Application No: P/157/21/PL
Site Address: 31 Lagoon Road Pagham PO21 4TQ
Description of works: Demolition & erection of 1 No dwelling (resubmission following P/56/21/PL). This site is in CIL Zone 4 and is CIL Liable as new dwelling.

Thank you for your internet representation made on 23rd December 2021 which has been recorded as an objection with the comments as follows:

DRAWING NUMBER: B_200

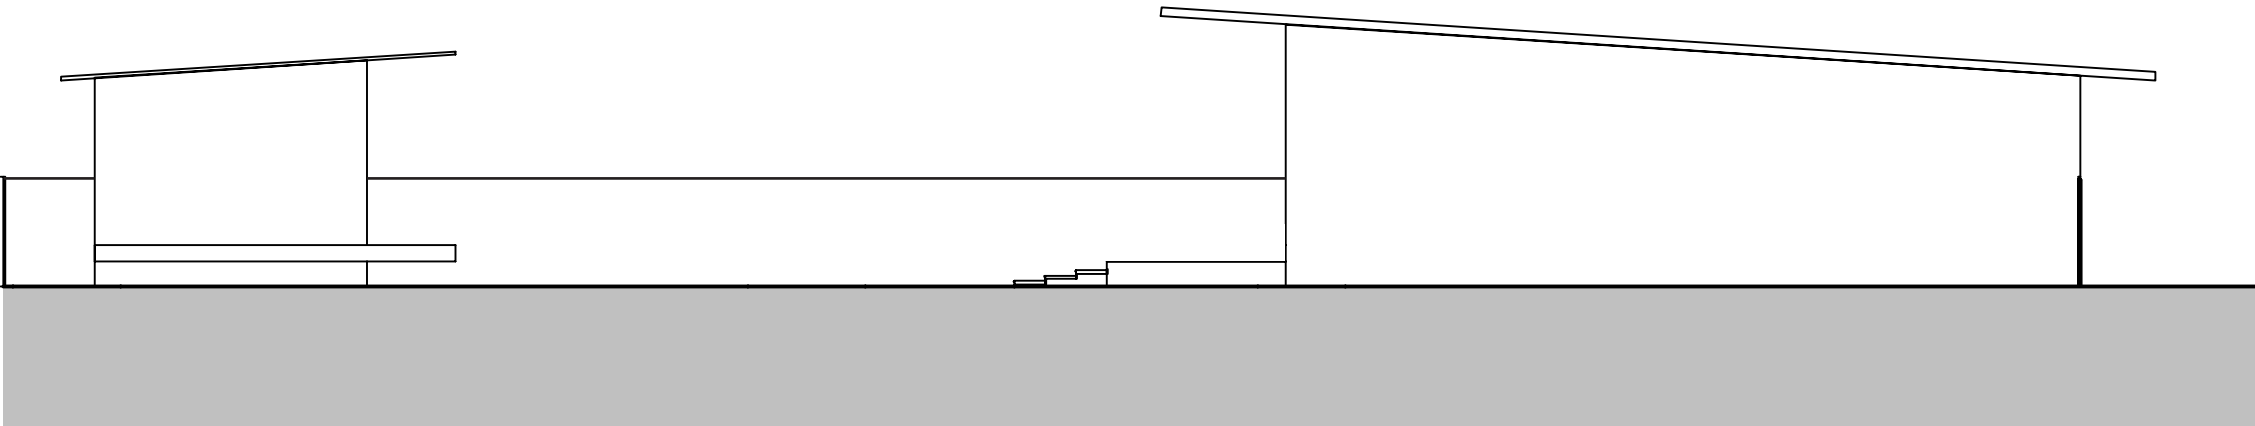
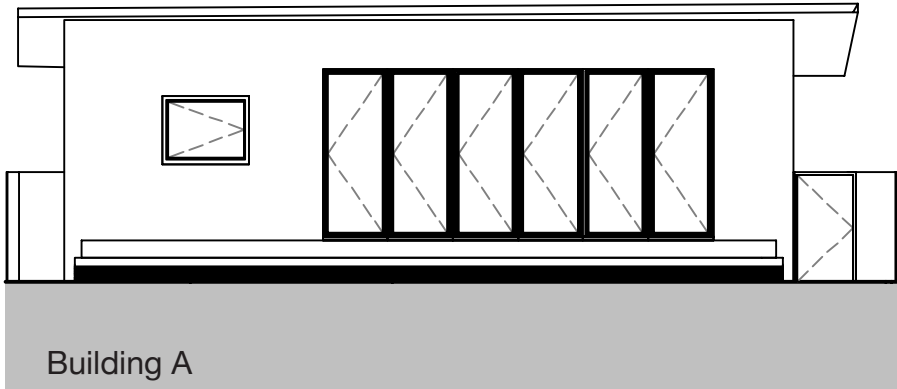
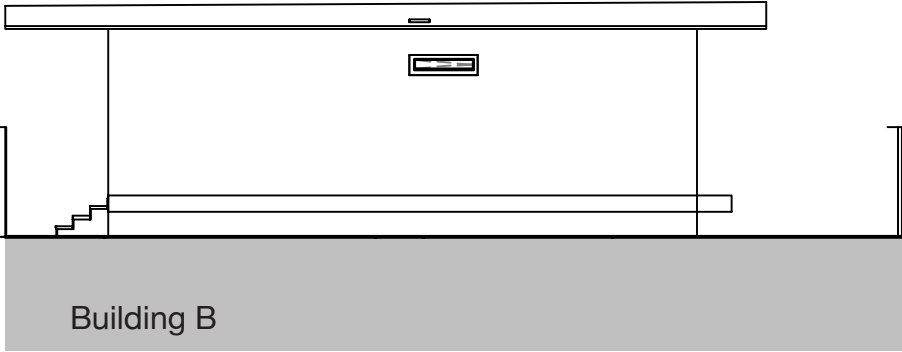
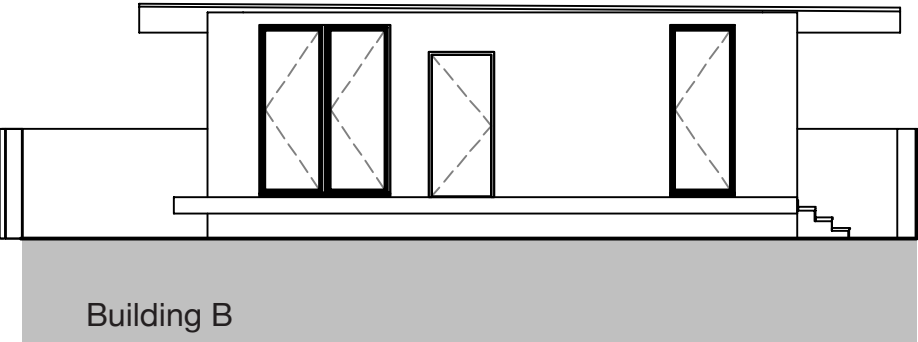
If the intention is that this development will be a single dwelling why can building B not be incorporated into building A ?

Building B is clearly intended as a 'Holiday Let ' with the attendant negative impact this may have upon adjoining neighbours with barbeques , music etc etc
The building will also impose upon my garden due to its proximity to the boundary
I believe that this represents a clear change of use of the premises i.e. back garden development
